Rezoning Transportation Analysis

Petition Number: 2020-052

General Location Identifier: Tax ID 15101603

Date	Description
4/20/20	First Review (MMagnasco)
08/25/20	Second Review (L Jensen)
09/22/20	Third Review (LJensen)

JOB # 20005
DATE 03/06/20
SCALE: 1" = 20'
DRAWN BY: JAW
APPROVED BY: JCO
RZ 1.0

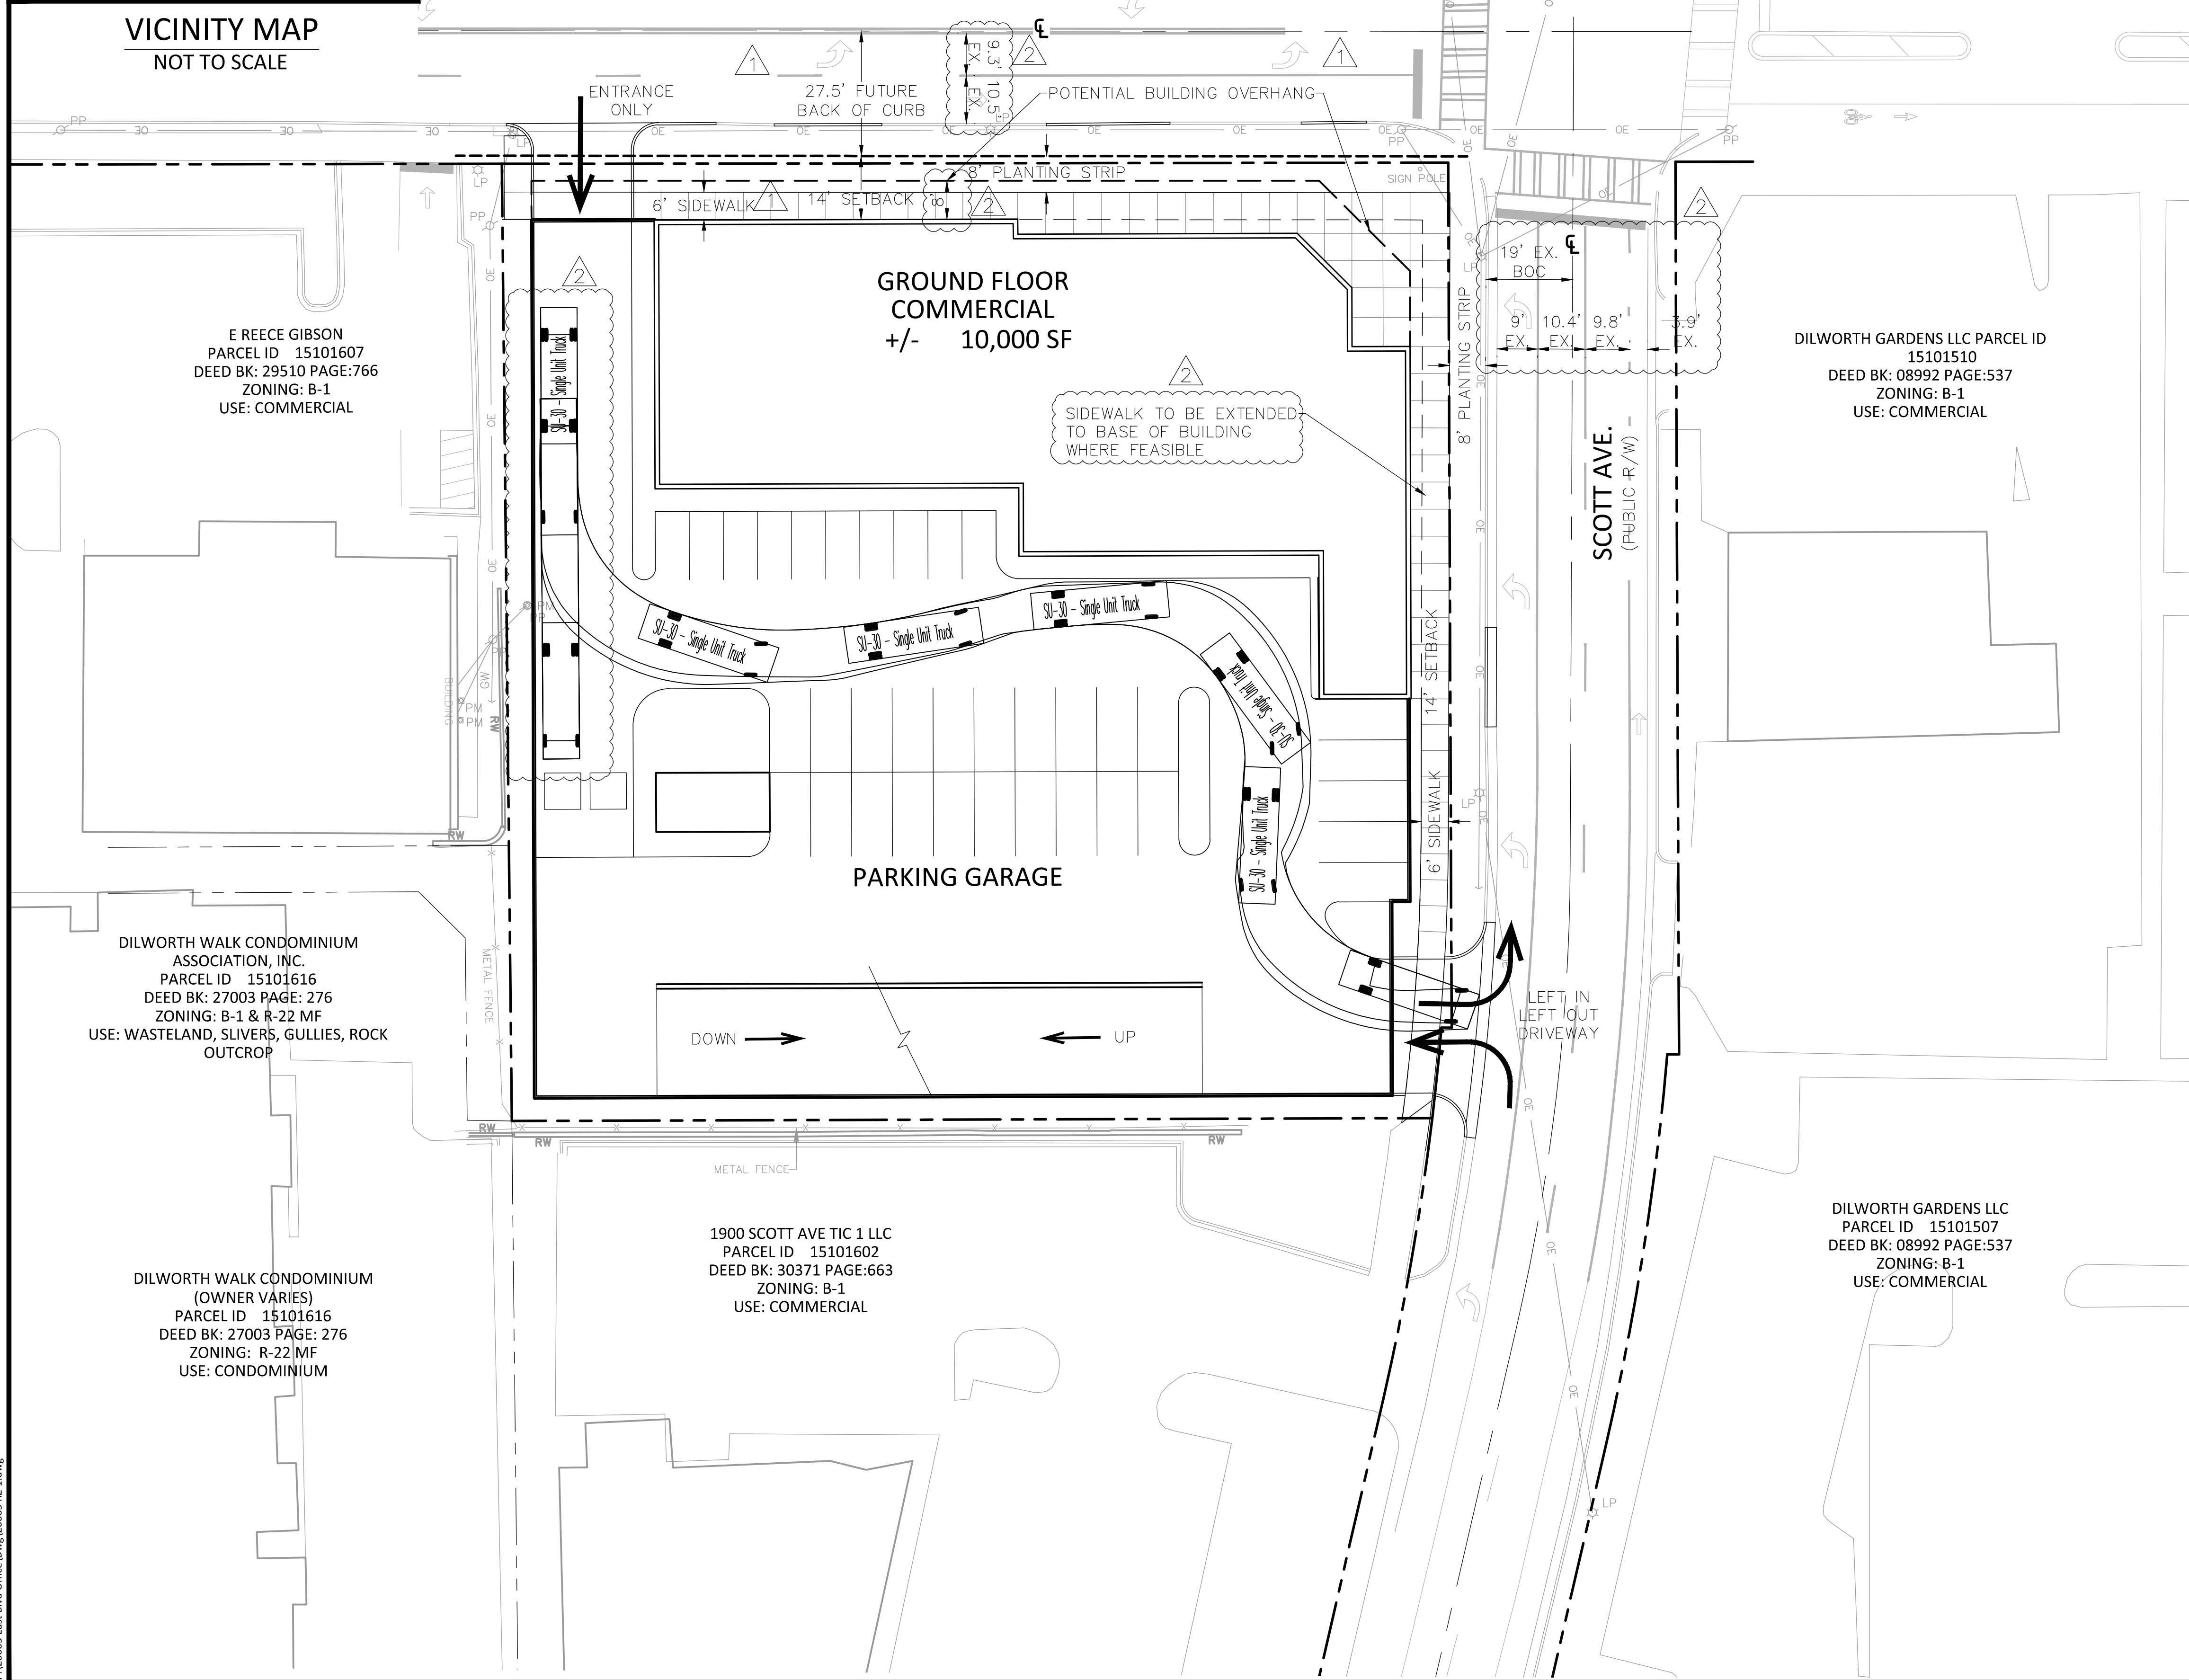
The site is located on the southwest corner of the signalized intersection of East Blvd./Scott Ave. in the commercial core of Dilworth. The petitioner needs to revise the site plan to the curbline as required by City ordinance.

1. **Curbline:** The proposed zoning district has a setback measured from back of the existing or proposed future curbline.
 - a. **Scott Ave.:** The future location of curb and gutter is in its existing location.
 - b. **East Blvd.:** The proposed curbline and setback need to be revised from what is shown on the site plan. ~~The East Blvd. Pedscap Plan (2002) prescribes a 54-foot back-of-curb (BOC) to back-of-curb dimension with a 12-foot setback. However, this plan predates the East Blvd. Road Diet (circa 2005), the Urban Street Design Guidelines, Charlotte WALKS, and Charlotte BIKES. After considering all of these plans, the future curbline should be 55-foot BOC-BOC (27.5-foot centerline to BOC) with a 14-foot setback:~~
 - ~~Four 10-foot vehicle lanes~~
 - ~~Two 5-foot standard bike lanes~~
 - ~~Two 2.5-foot curbs and gutters~~
 - ~~Two 14-foot hardscape setbacks~~
